Planning Application EP/160/19/PL

Land to the rear of 43 Sea Road, East Preston

Demolish redundant external store and former outside toilet at rear of 43 Sea Road and construct a single storey extension to create a 2 bedroom apartment

SITE PLAN 1:500 @ A4

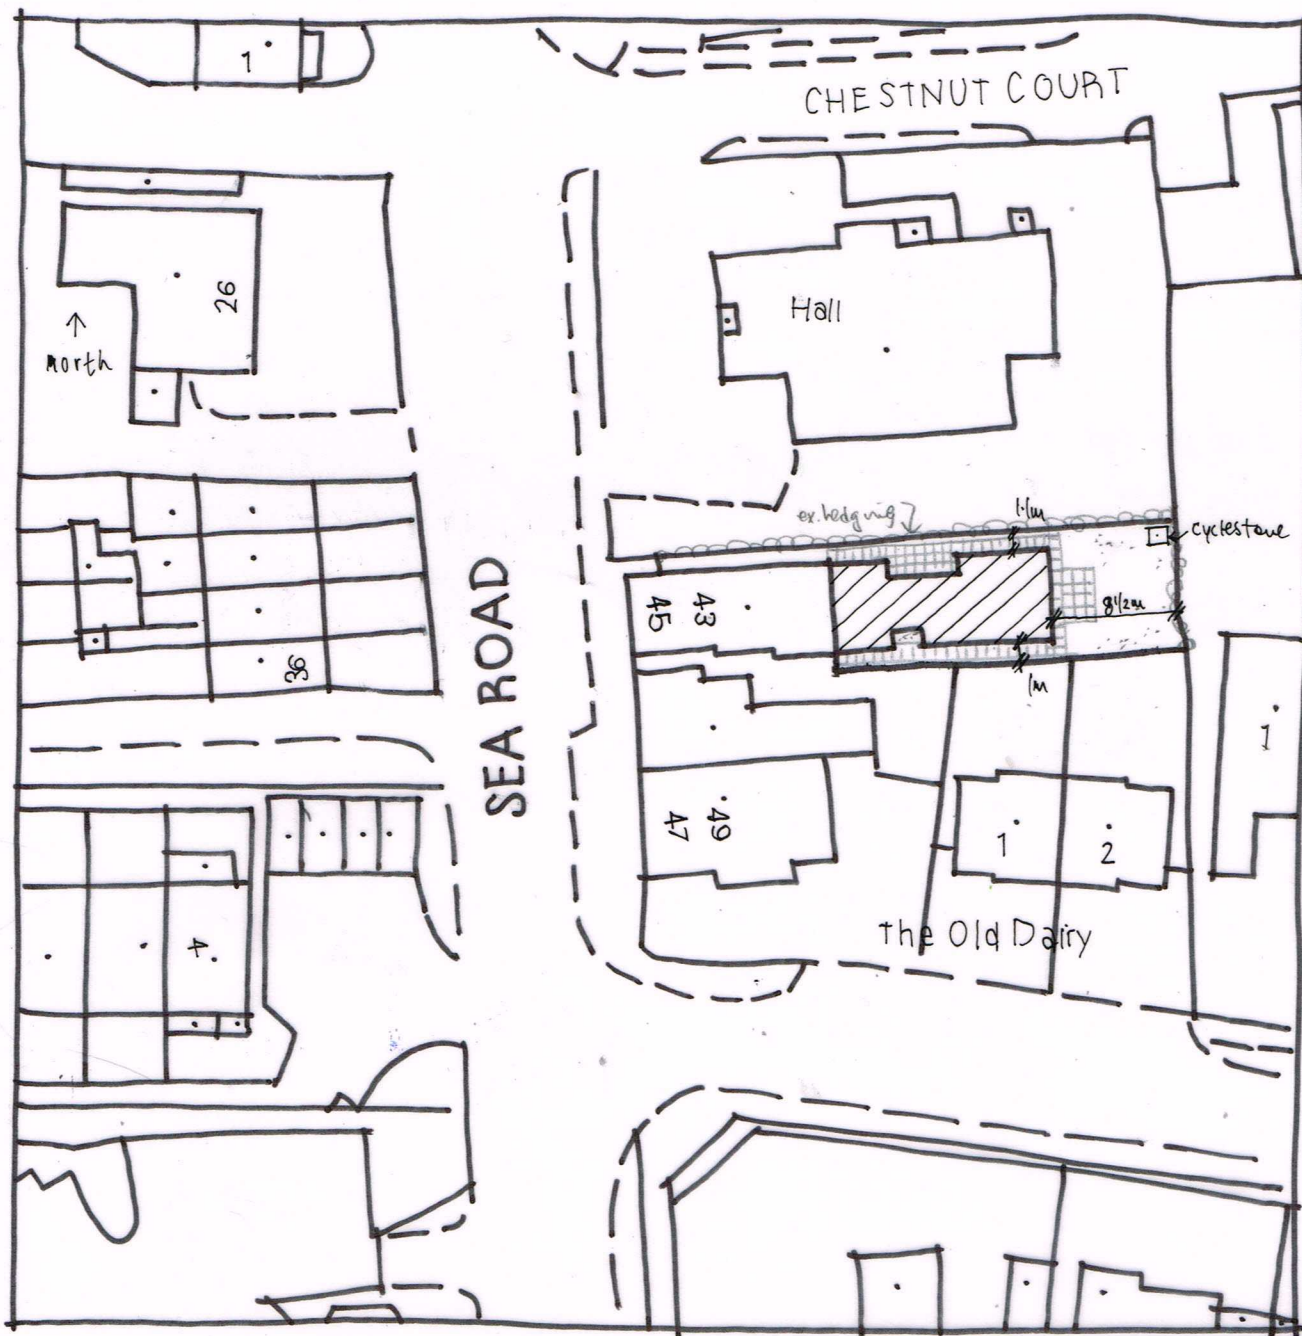
3. The OS plan submitted is labelled incorrectly. It shows no.43 and 45 at the same location. The property to the south of 43 should be noted as 45.
4. The area of the proposed new dwelling is larger than the existing building and would more than double the existing footprint which is therefore clearly over-development.

GROUND FLOOR PLAN 1:100 @ A3 / 1:50 @ A1

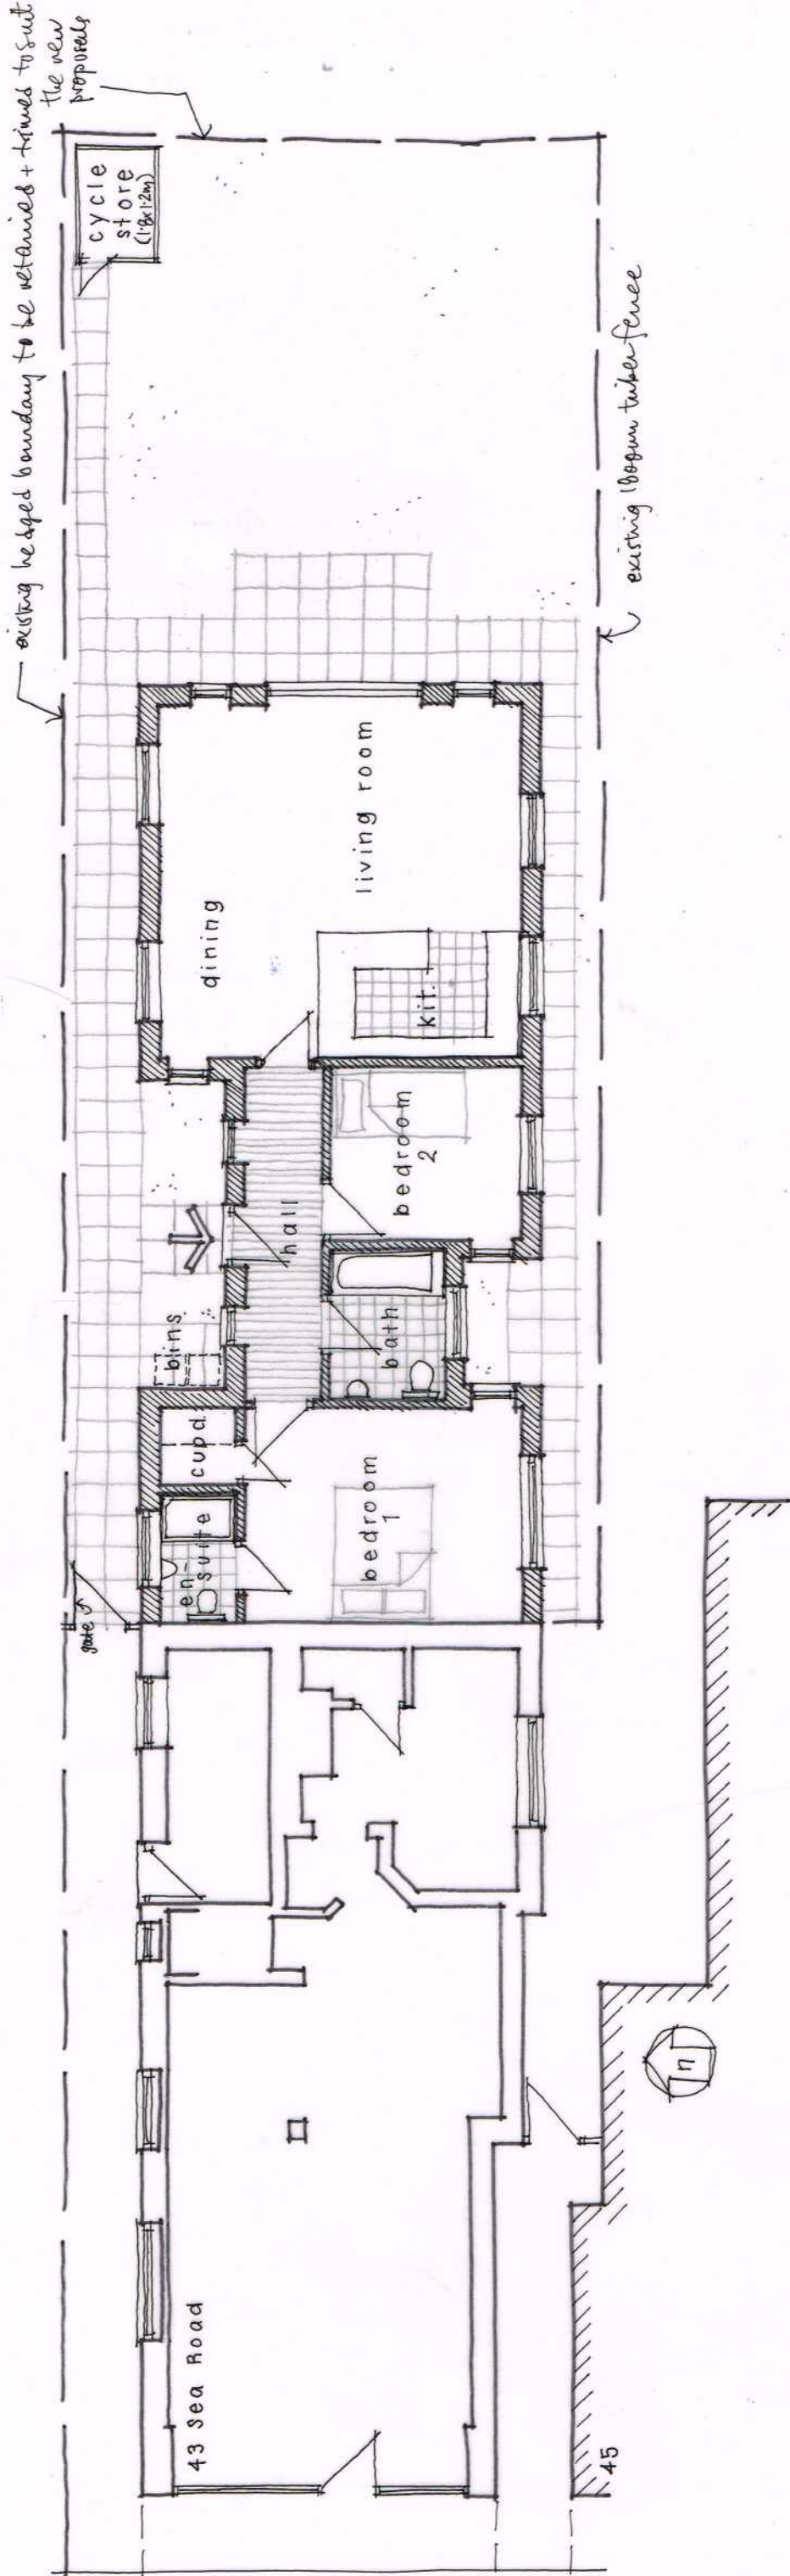
7. The proposal is inconsistent with the surrounding architectural styles.
8. The drawings do not provide any dimensions to check if the scheme complies with the National Space Standards.

PROPOSED ELEVATIONS

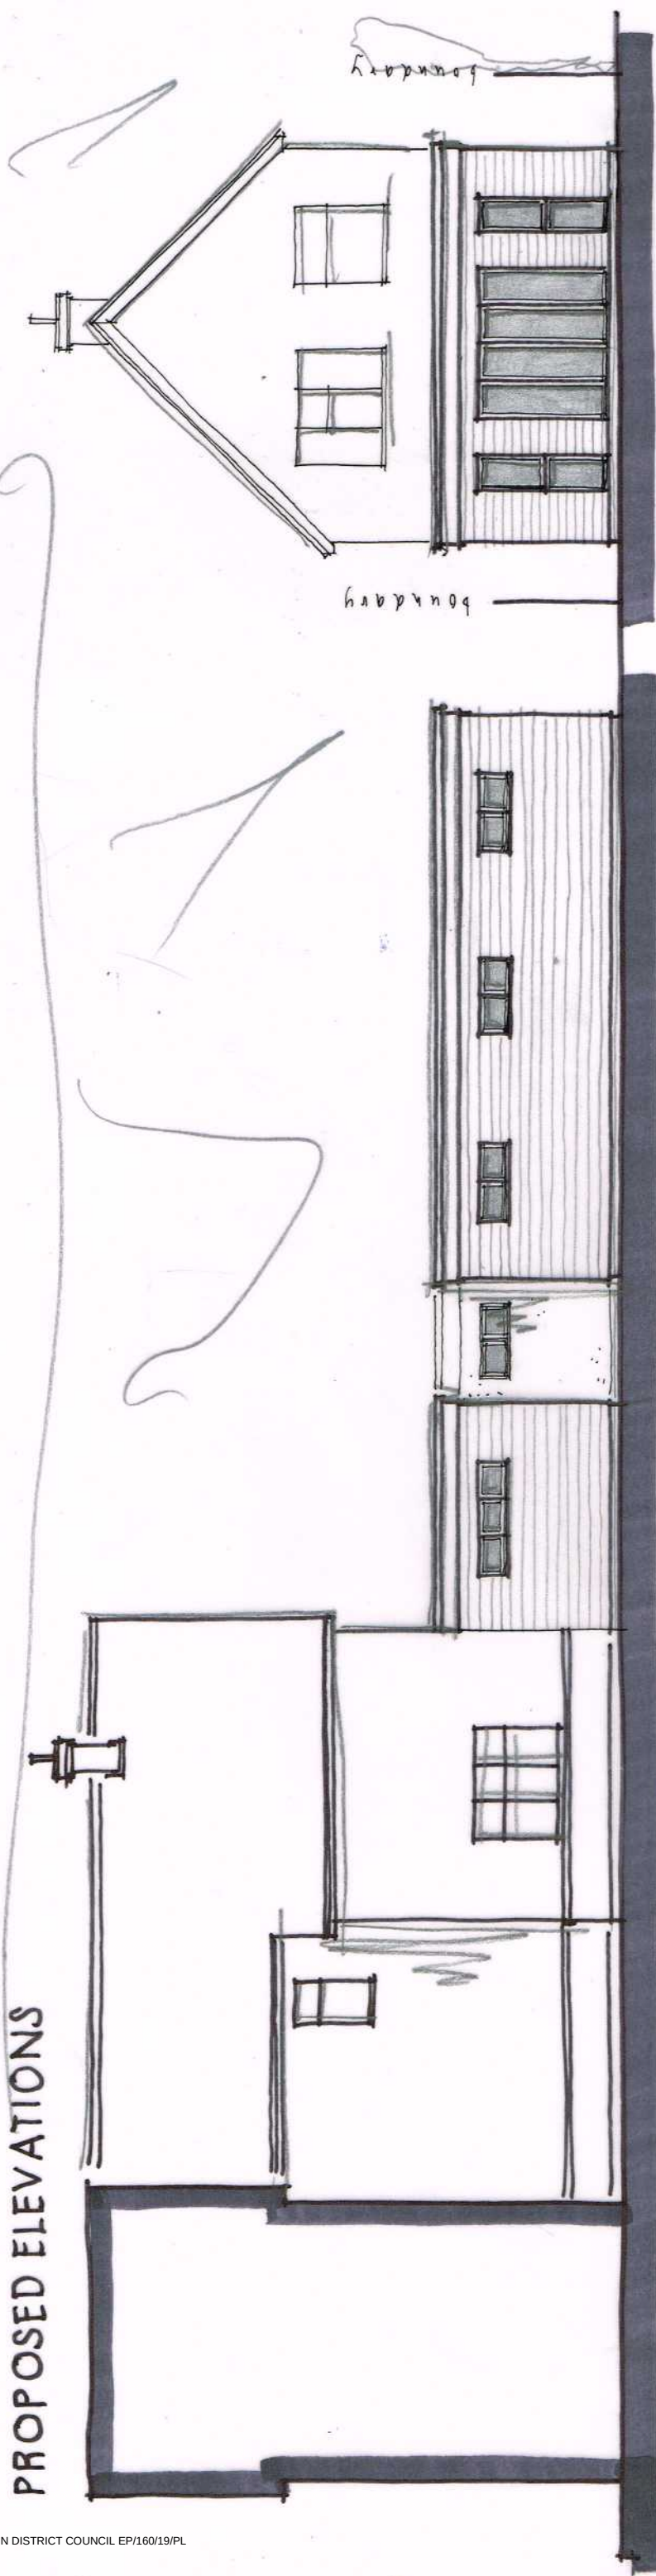
9. There are no height dimensions to be able to properly appreciate the impact on the neighbouring properties and their amenity spaces. However the building will be clearly visible from the neighbouring gardens creating an overbearing detrimental effect on their outlook and amenity spaces, especially the garden that serves the residential unit at 45b Sea Road.
